F PLANNING REPORT

Belvor Close, Spalding, Lincolnshire. PE11 3FZ

Planning Reference H14-0391-21

Erection of chill store, collation, loading dock together with offices, self store containers and car parking.

copyright reserved ©
Drawing Title PROPOSED SITE PLANS Drawing number dc/578F/01
Scale 1:400 Drawn DB Revision H
Date OCT 2020

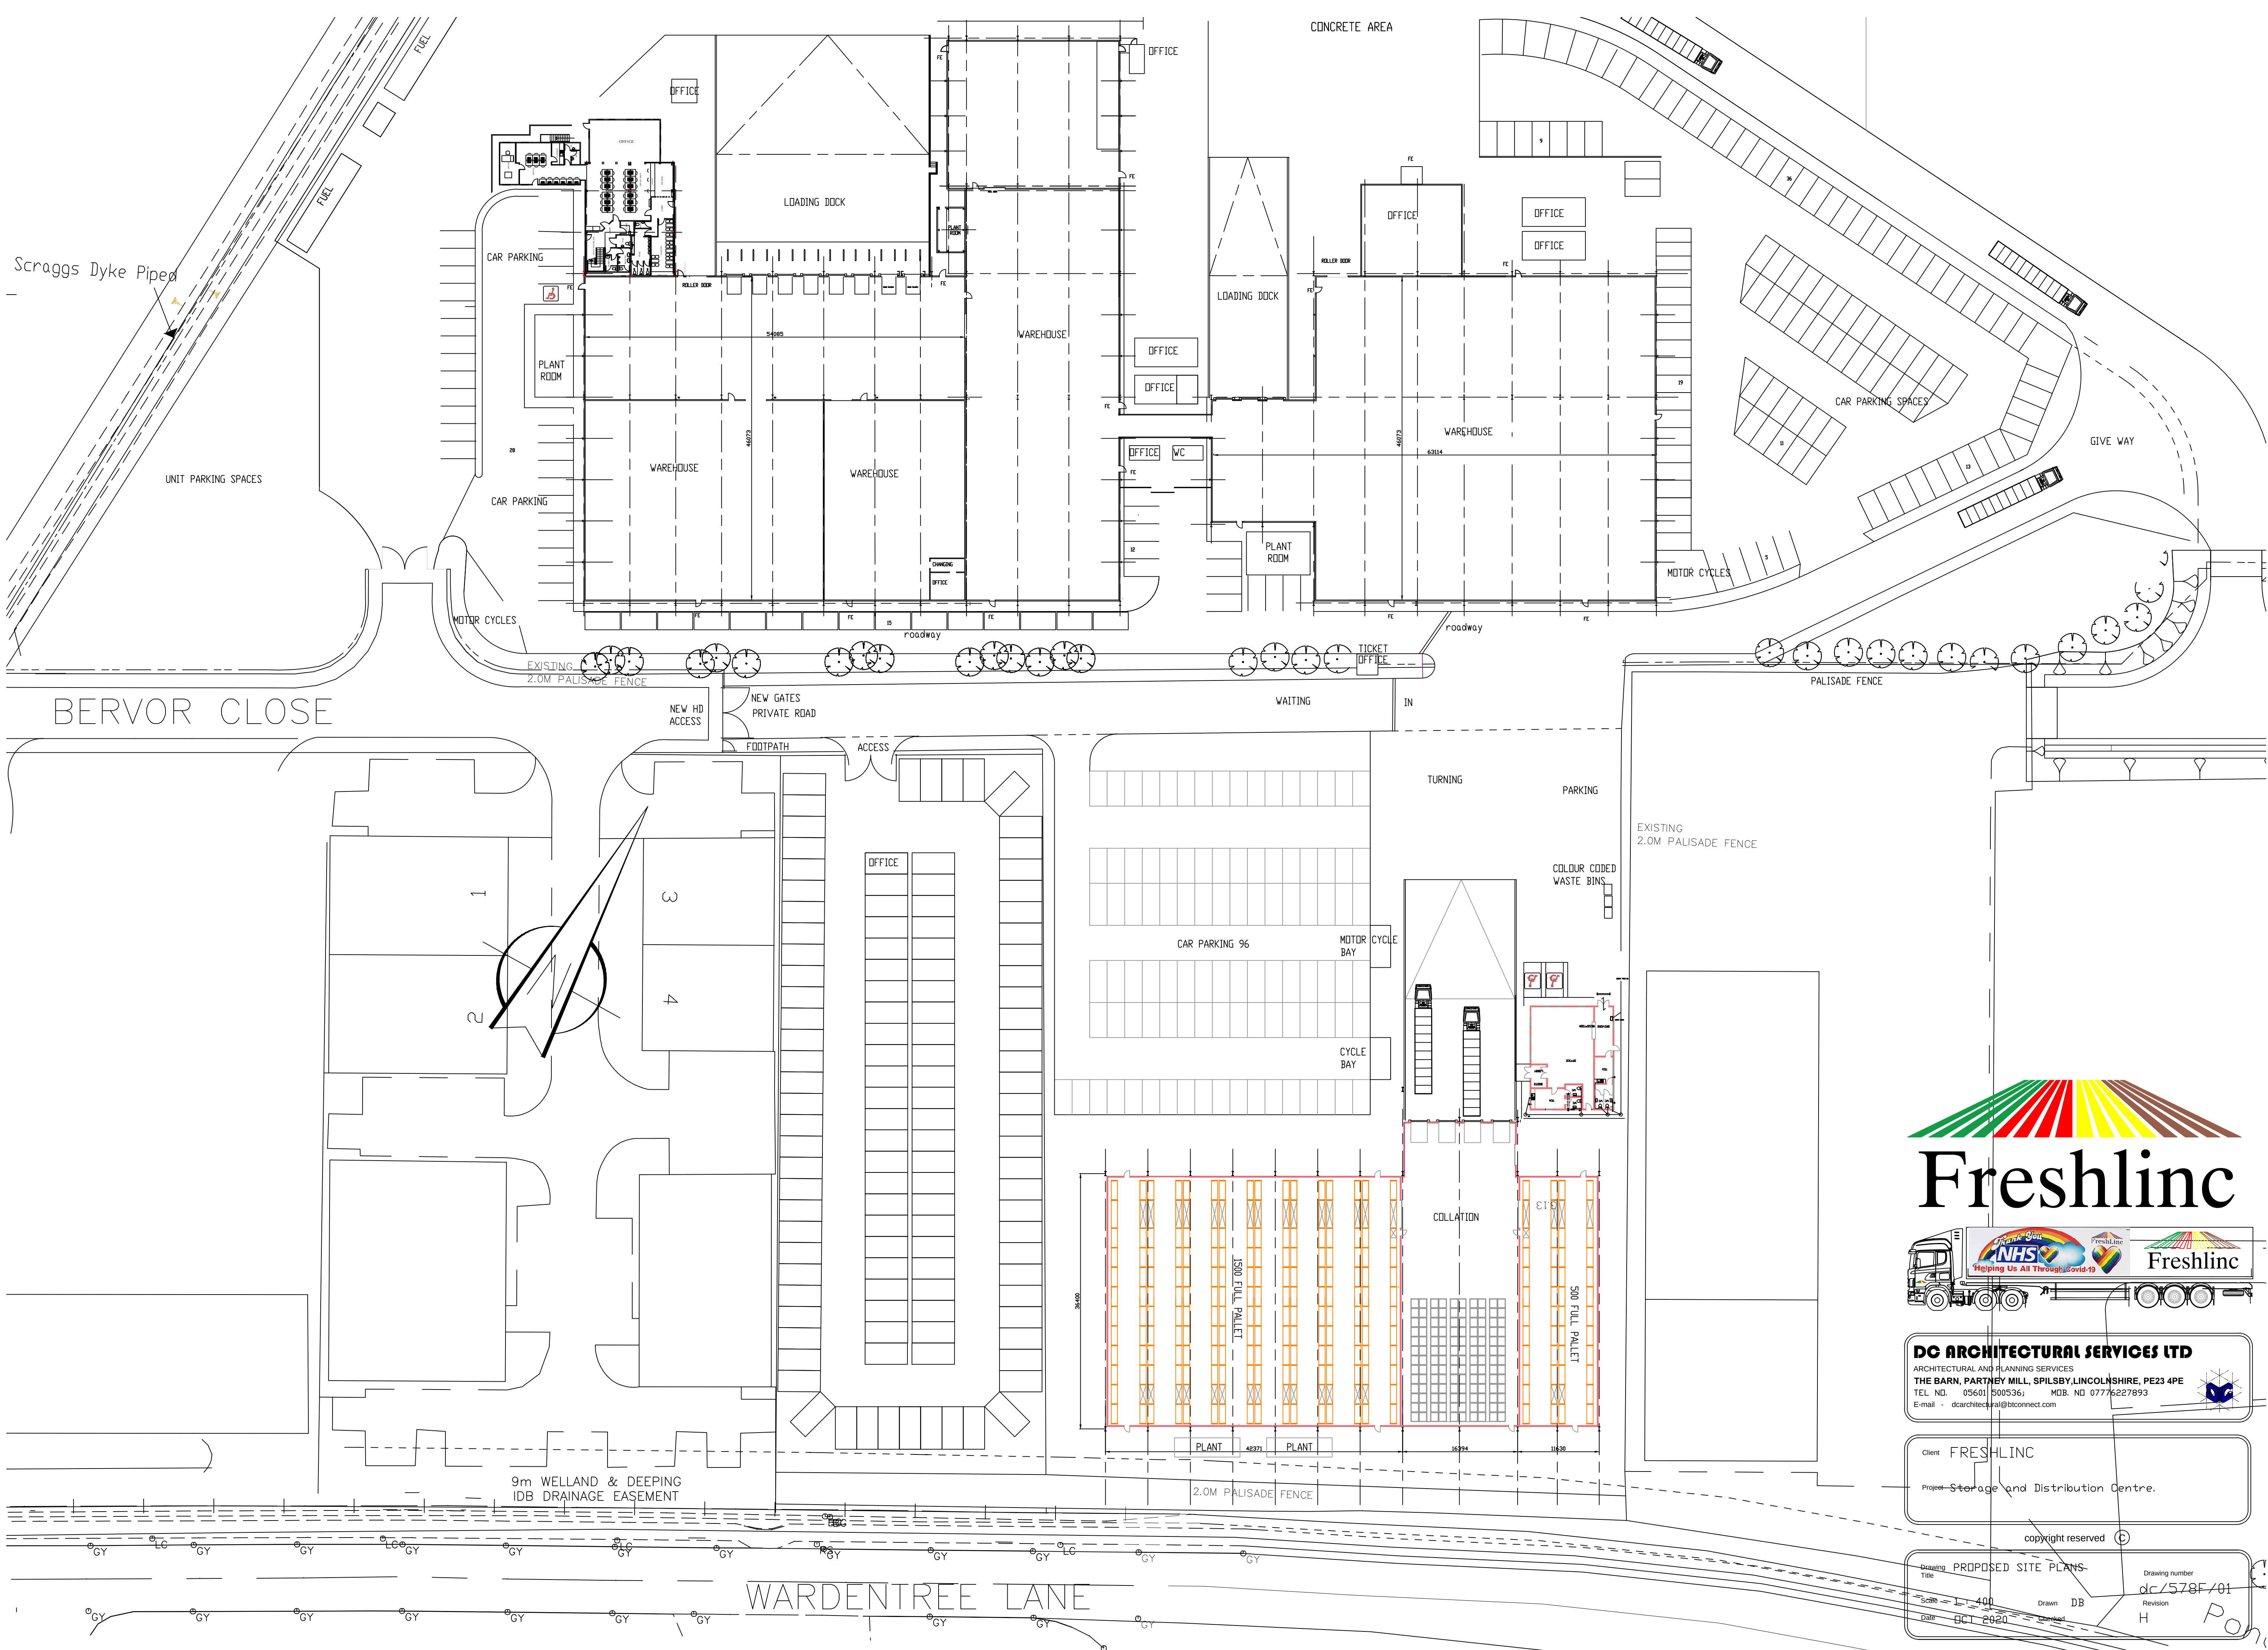
Section 3 used water network, AWA state that they have used :- application form, location plan, flood risk assessment and design access statement for making their assessment and further comment there is insufficient information clearly they should read the site plan and the drainage plan provided with the application.

AWA have not in our view undertaken a topo survey or made any assessment on the provision of foul water drainage. We have on the other hand have done so and there is sufficient private foul drainage on the site which connects to the AWA foul sewer in Platts Close.

The Manhole existing (private) F2 inv 1.560 ODN shown on our drainage plan ultimately connects (Private) F1 inv 1.150 ODN on a lateral provided as part of the Platts Close adopted sewer development.

Our floor level is 3.150 ODN with an in pipe gradient of 1:85 we can provide gravity fall for the proposal.
